CITY OF PORTLAND

BUILDING PERMIT

Job ID: 2011-06-1271-ALTR

has permission to build a 21 foot by 34 foot attached garage.

Section " A "		Garage Addition	
Plan For:	Marvin Ouellette	3	3
Drawn by:	Wayne Paradis	May, 31, 2011

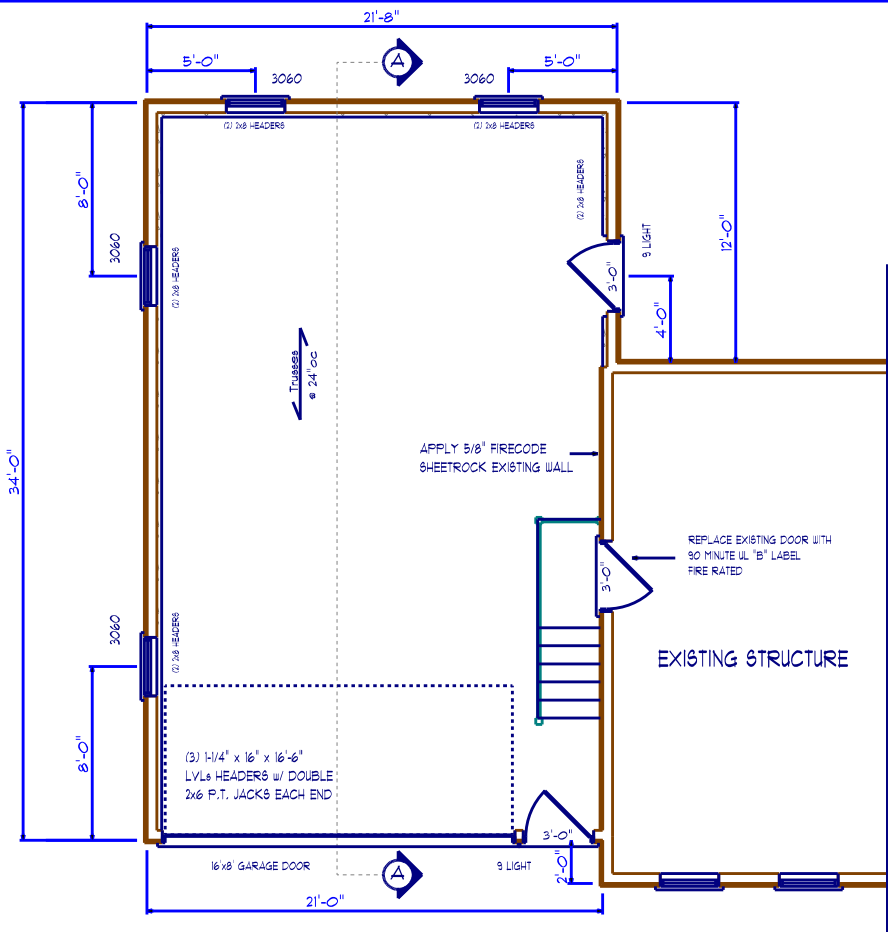
1. Stairway headroom shall be not less than 6 feet 8 inches measured vertically from the sloped plane adjoining the tread nosing or from the floor surface of the landing or platform.

3. **R302.6 Dwelling/garage fire separation.** The garage shall be separated as required by Table R302.6. Openings in garage walls shall comply with Section R302.5. This provision does not apply to garage walls that are perpendicular to the adjacent *dwelling unit* wall.

SEPARATION	MATERIAL
From the residence and attics	Not less than 1/2-inch gypsum board or equivalent applied to the garage side
From all habitable rooms above the garage	Not less than 5/8-inch Type X gypsum board or equivalent
Structure(s) supporting floor/ceiling assemblies used for separation required by this section	Not less than 1/2-inch gypsum board or equivalent
Garages located less than 3 feet from a dwelling unit on the same lot	Not less than 1/2-inch gypsum board or equivalent applied to the interior side of exterior walls that are within this area
